About the application

Application number: 2020/94184	
What is the application for?:	Erection of car port (Within a Conservation Area)
Address of the site or building:	Stonecroft, Daisy Lea Lane, Lindley, Huddersfield, HD3 3LL
Postcode:	HD3 3LL

Daisy Lea Lane

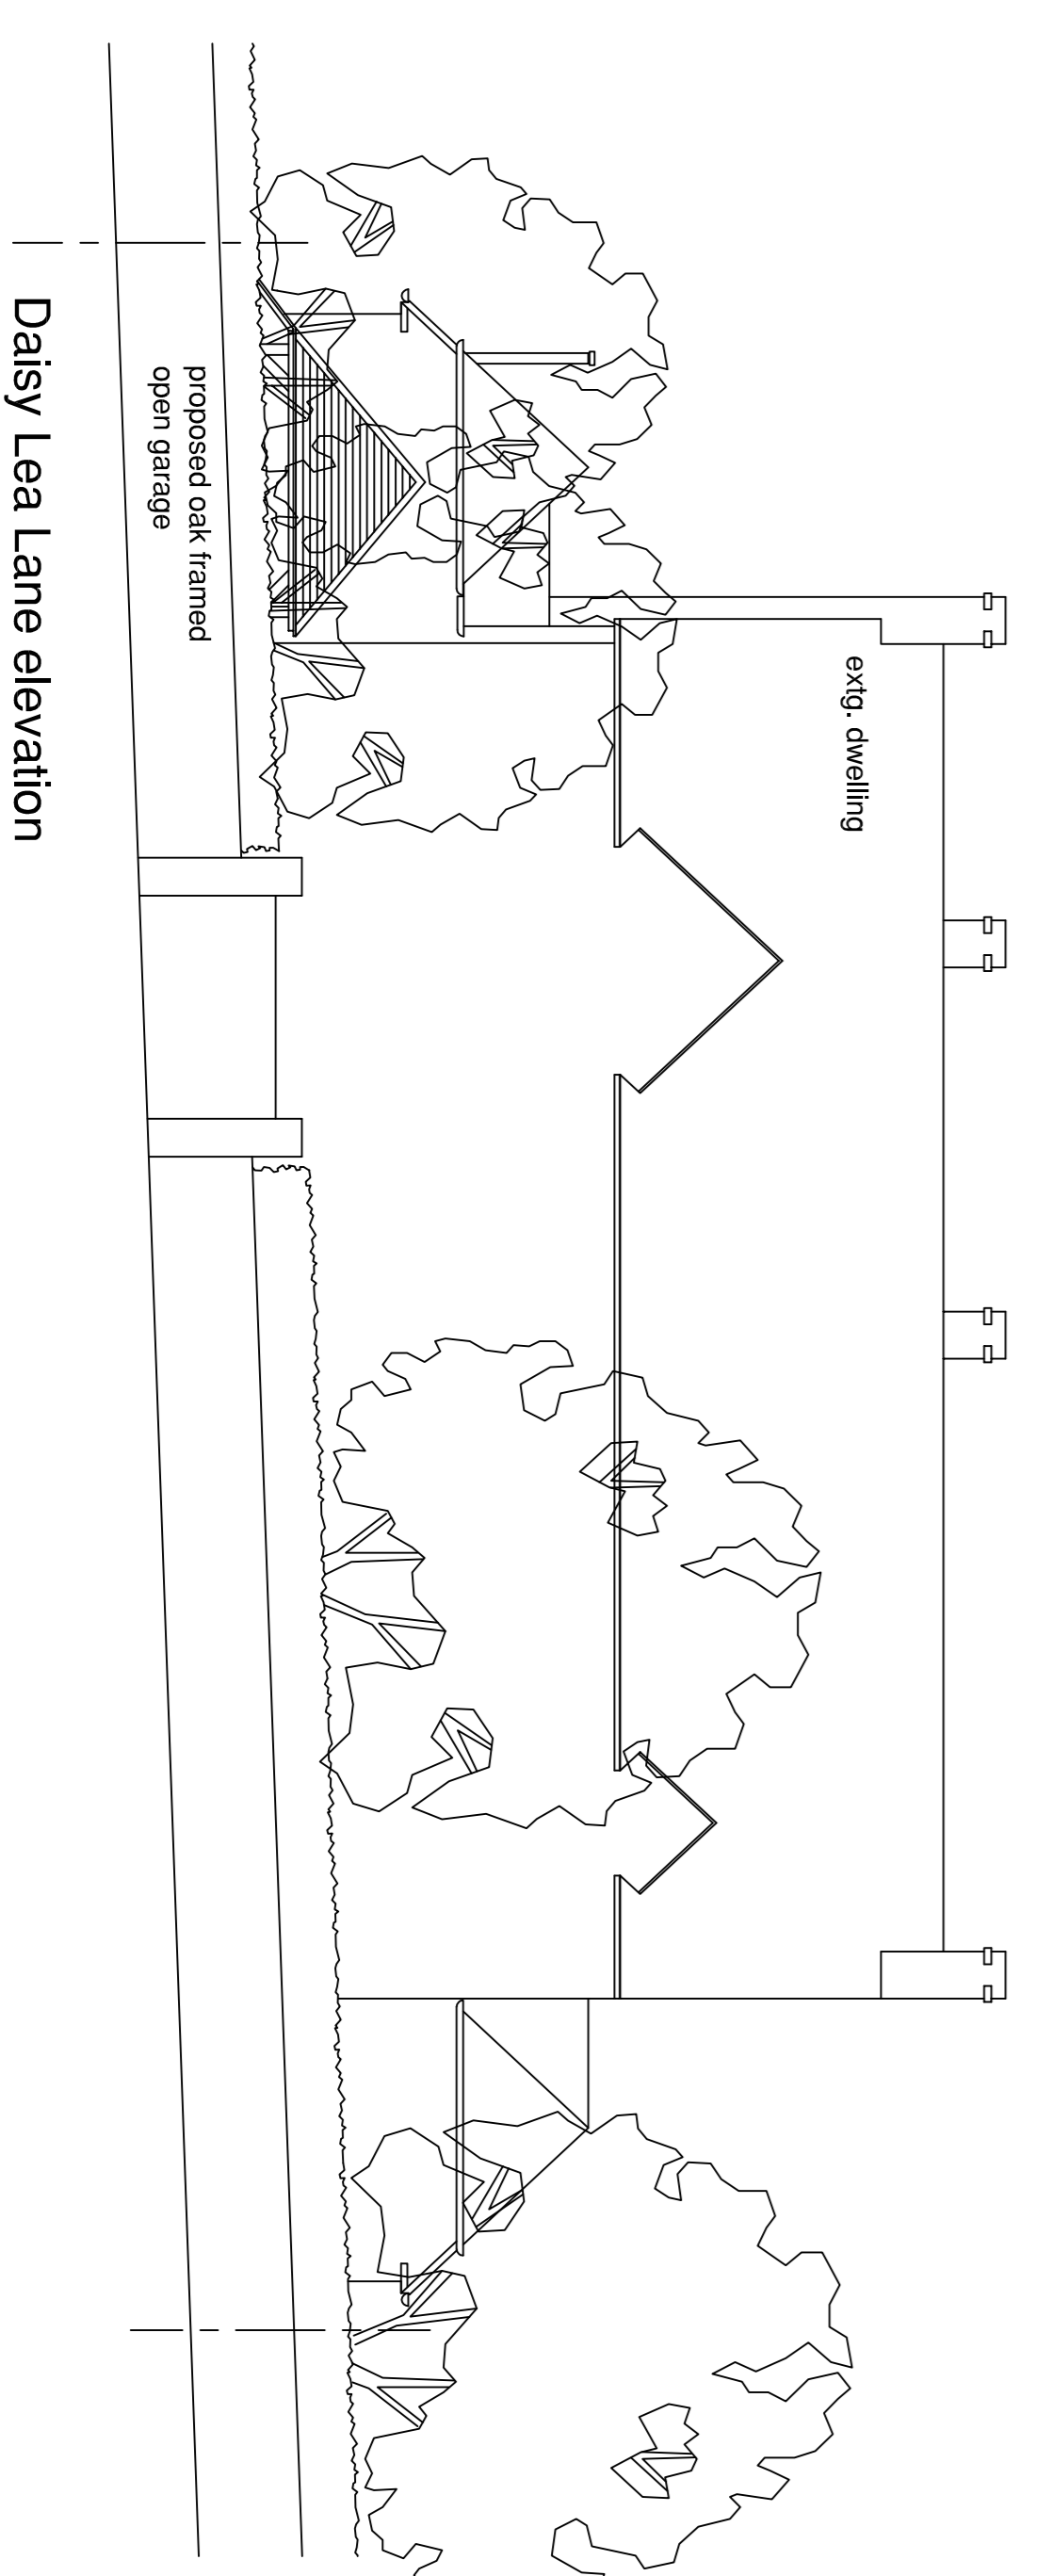
This proposal (application 2020/94184) is to add a new, free-standing car port 6.25m x 5.0m x 3.99m high filling much of one side of the space between house and road. The lower part of this structure would be see-through between oak posts, but the part between 2.1m and 3.99m above ground would be tiled roofing. To accommodate this structure it is intended to remove large rhododendrons and a holly along the side boundary of this property, remove substantial branches from two full-size laburnum trees close to the Daisy Lea Lane boundary and remove a major part of an attractive large, mature magnolia closer to the house. There is no mention of foundations being required, how close they would be to the road or side boundary or the potential for damage to the roots of the laburnums and magnolia. A recent application for a similar, slightly larger, car port with tiled roof in a nearby road described a need for foundations at least 1m deep.

I believe that the applicant's drawings omit specific information on a number of important matters including: distance from the proposed structure to the privet hedge and wall along Daisy Lea Lane, the actual surface area of green canopy to be removed and the need for, plus impact of, foundations.

- 1) This new free-standing building would constitute 'infilling' within the Edgerton Conservation Area;
- 2) It would be the first structure to be built in front of the building line on this section of road in the Edgerton Conservation Area and therefore spoil this line which has been maintained over many decades;

- 3) The prominent location, very close to Daisy Lea Lane as it rises away from Halifax Road, means it would be clearly visible along all of Daisy Lea Lane from the bottom at Halifax Road to the barrier across a much higher section of the road;

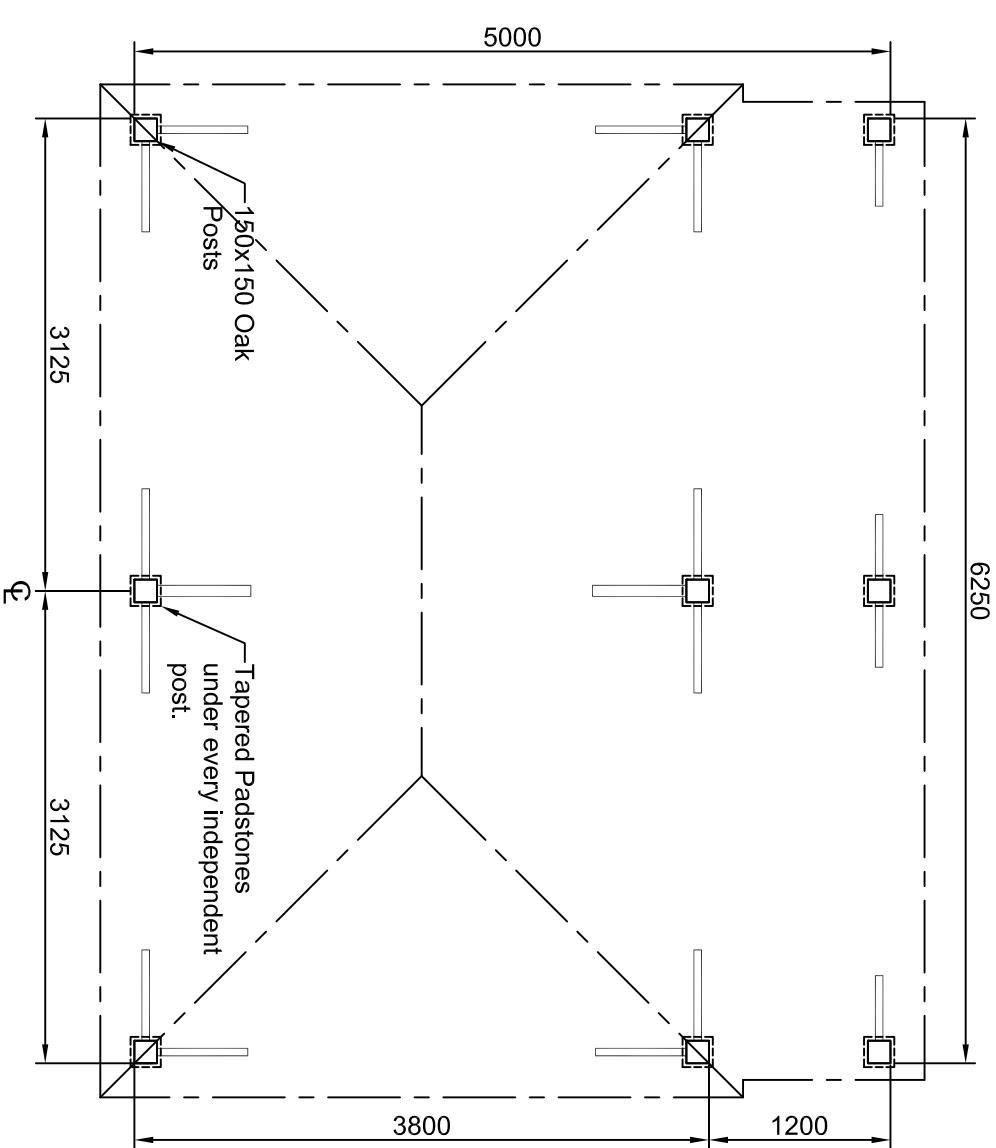
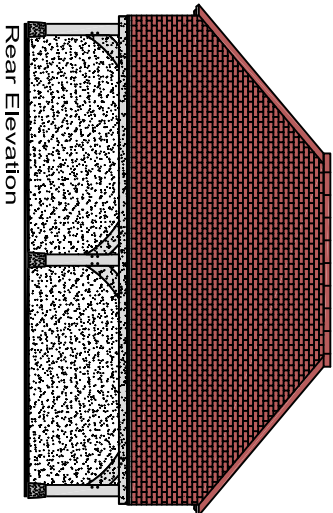
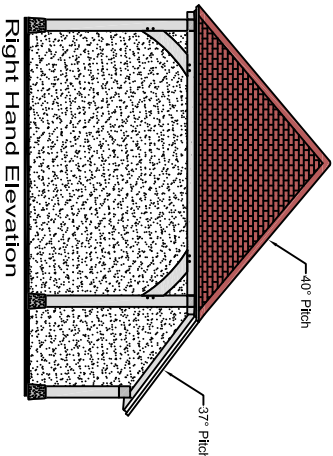
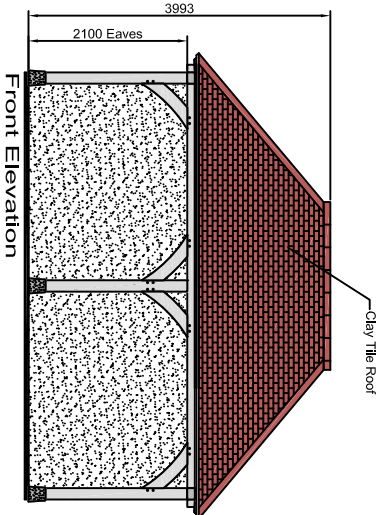
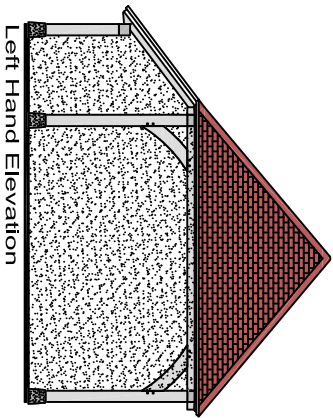
- 5) The lack of information as to the impact of the construction of foundations for this structure on the adjoining laburnums and magnolia (all proposed for severe cutback), giving no information as to whether these reduced trees would then be likely to survive after damage to their roots;

General view of site

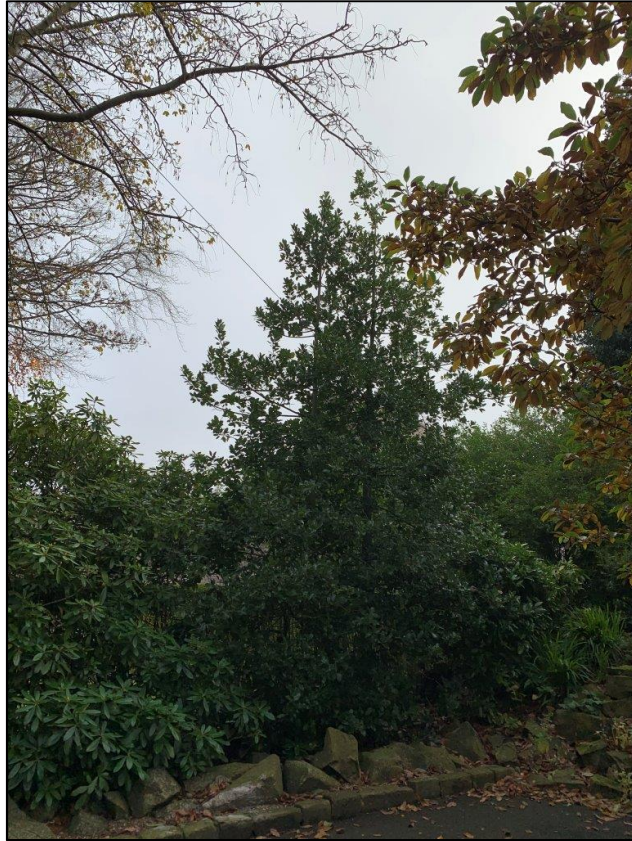
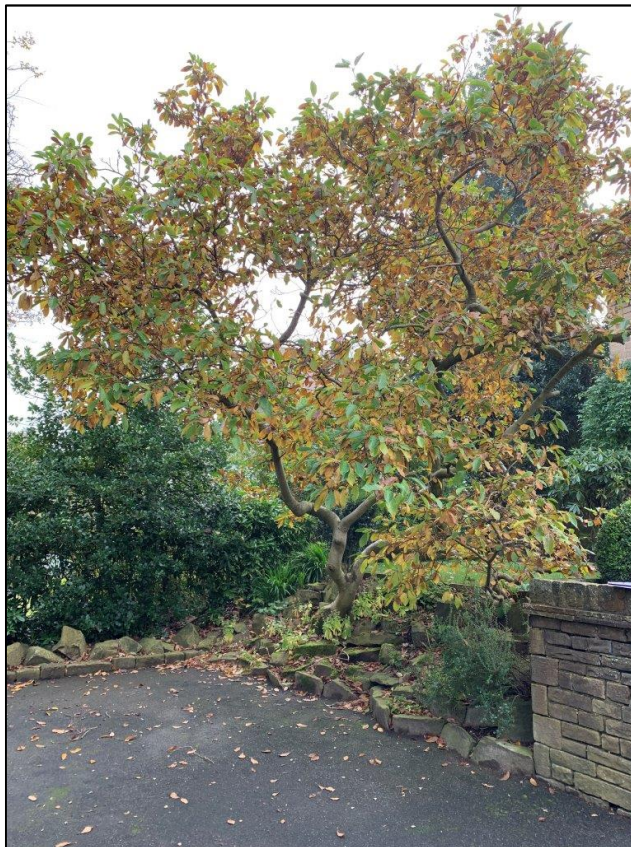
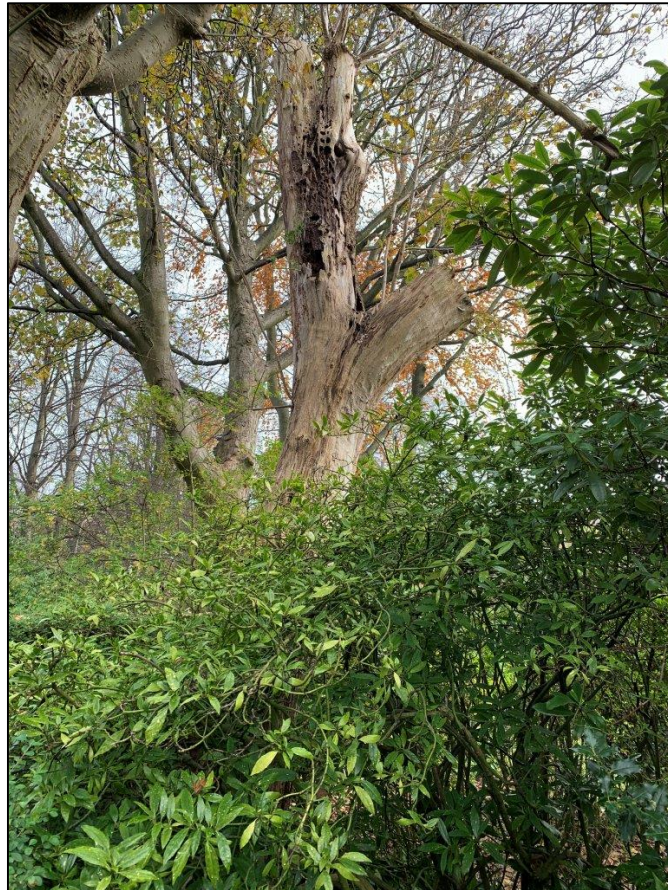
- 4) The shrub and tree removals and severe cutbacks required to provide space for the 'car port' would severely reduce the crown spread in front of the house and thus diminish the line of greenery and trees along Daisy Lea Lane that forms a significant and attractive feature of the Conservation Area;
